From: Fiona Fitzgerald
Sent: 01 May 2014 12:08
To: Simon Davis
Subject: FW: Planning Consultation on: AW/114/14/PL

I have assessed the Acoustic Noise Report submitted with this application, reference KR03715, dated 2nd April 2014. I would be grateful if you would ask the applicant to clarify the following:

APPLICATION NO: **AW/114/14/PL**

Description of Works: Instalment of two new external cold rooms to be positioned within the rear yard area.

PROPOSED PLAN LAYOUT

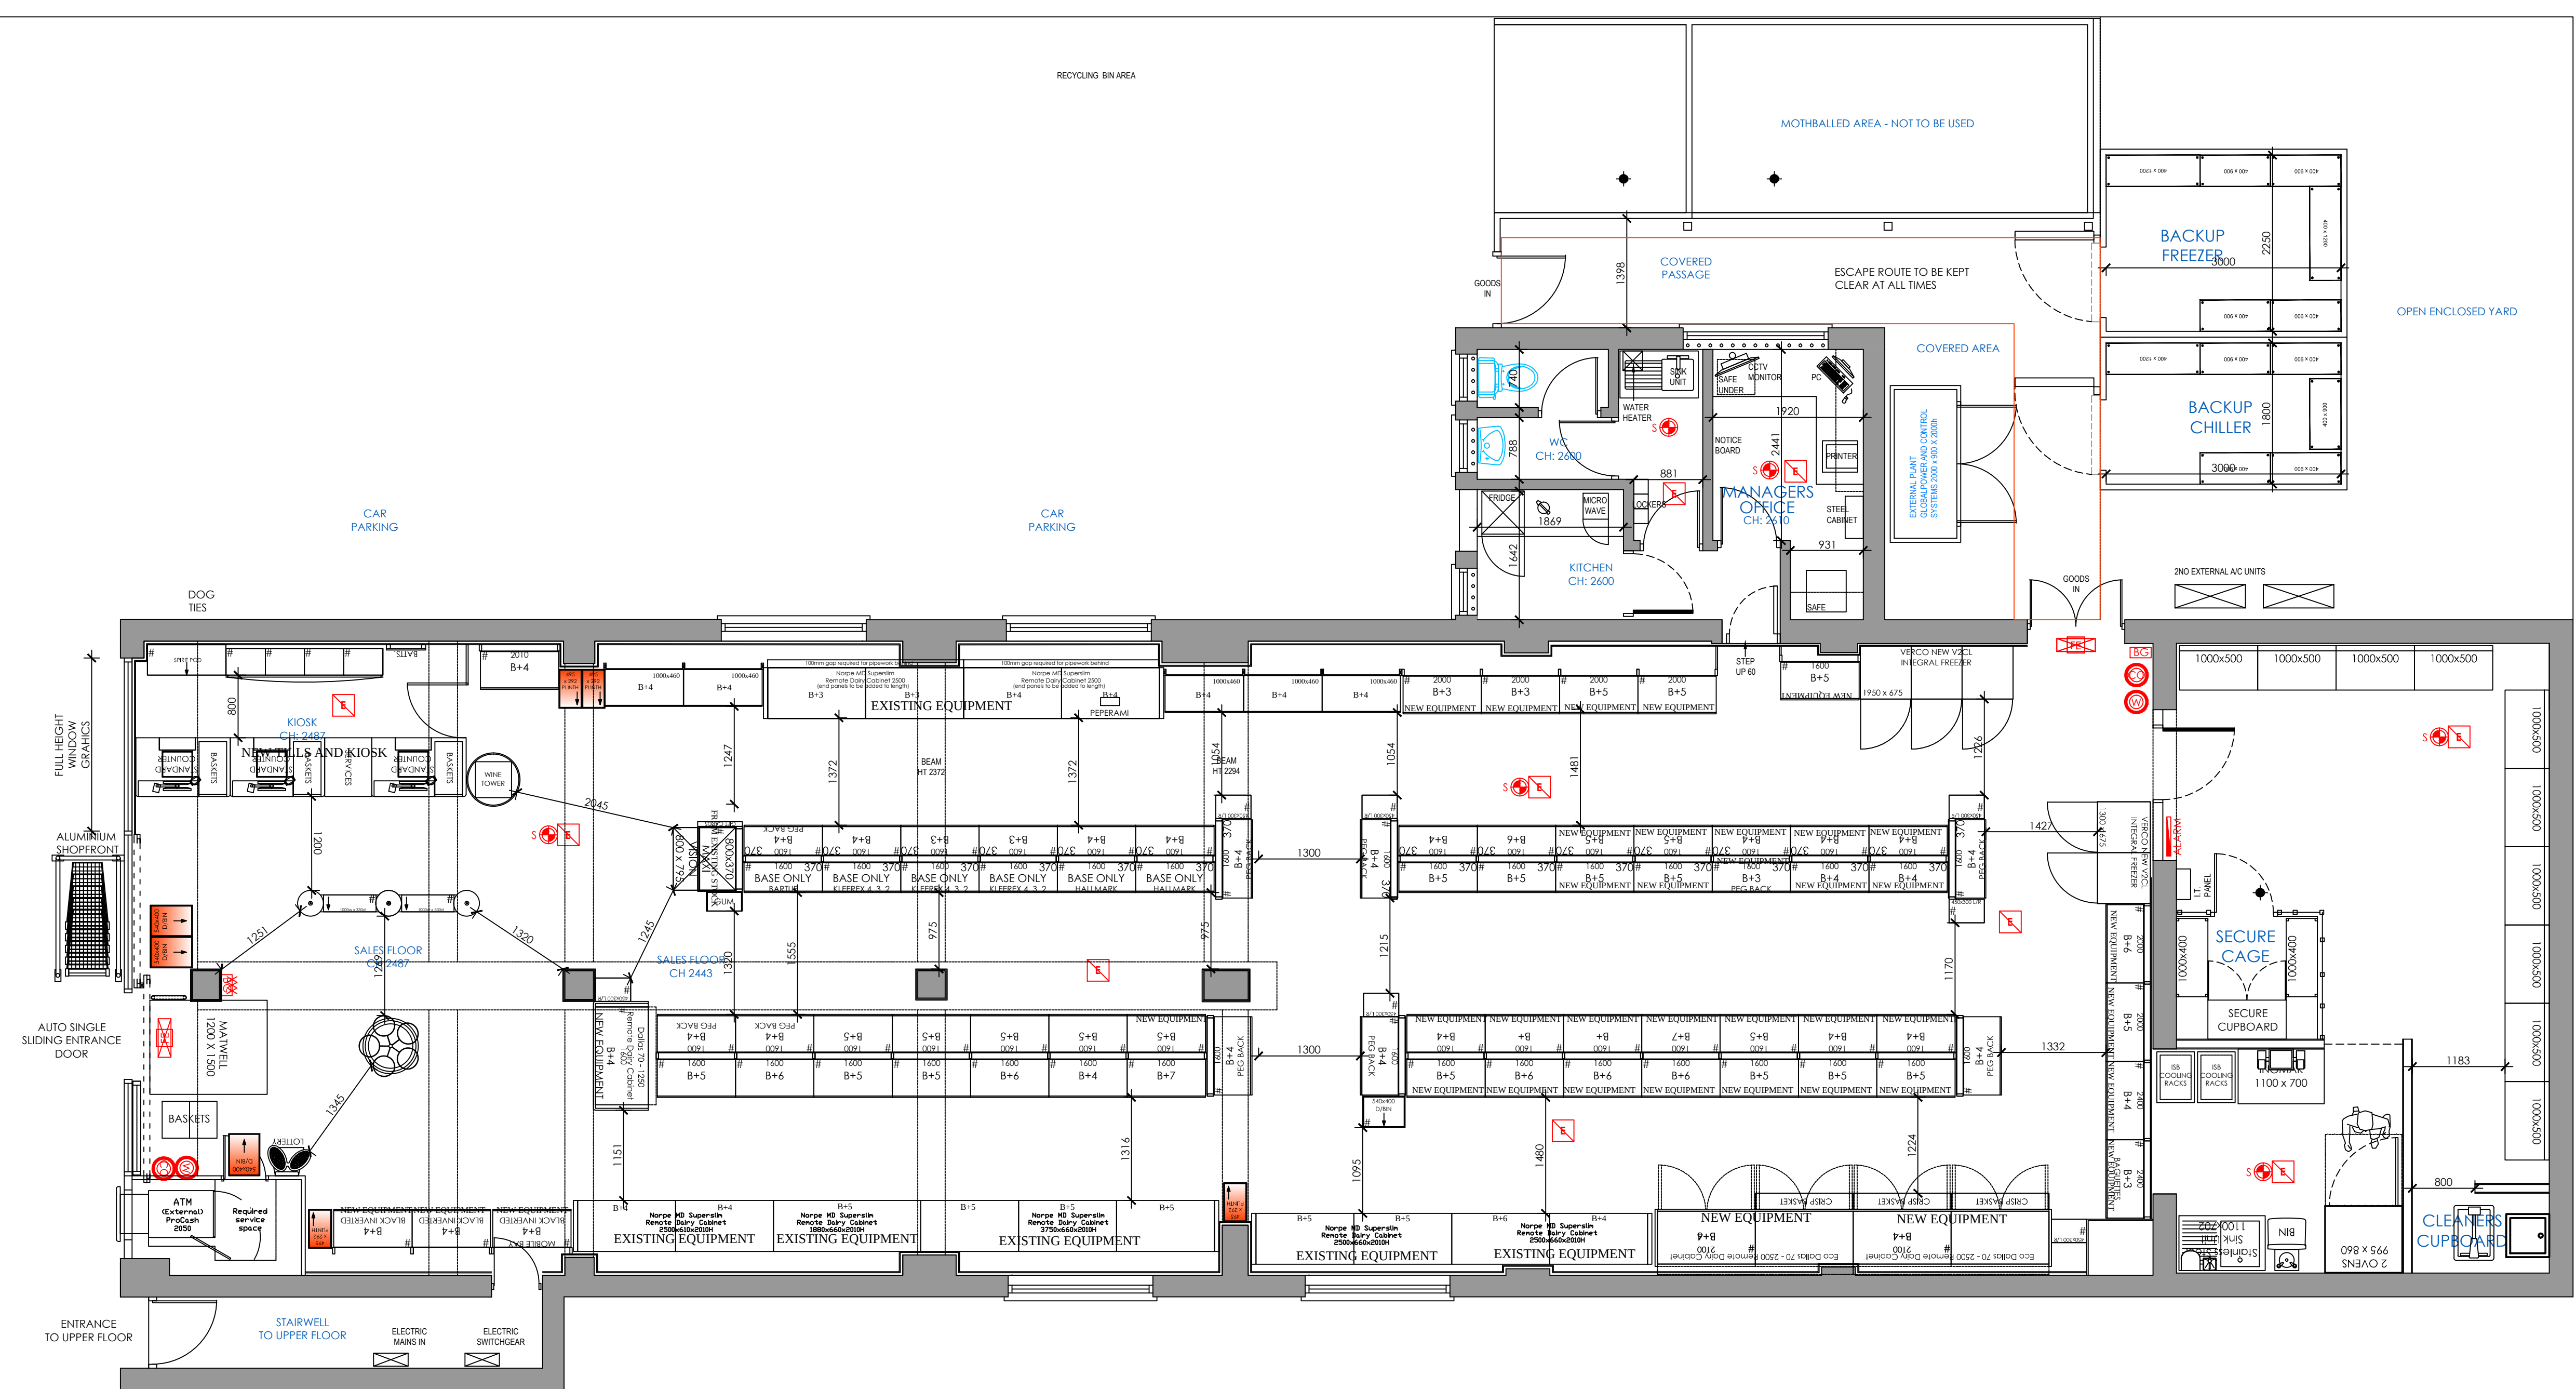
1. To specify the exact measurement positions used during the test, specifically where the measurements were taken, and what the tester considered the nearest noise sensitive premises to be. I consider that the nearest noise sensitive premises to be 72 Rose Green Road which is much closer than the 17.9m distance used in the report, and would therefore have an impact on the overall results.
2. To specify whether the fact that two units are to be installed has been incorporated into the calculations.
3. To specify whether the background noise assessment was taken with or without the current chiller/air conditioning units being operational, and what the operational hours of these current units are known to be.
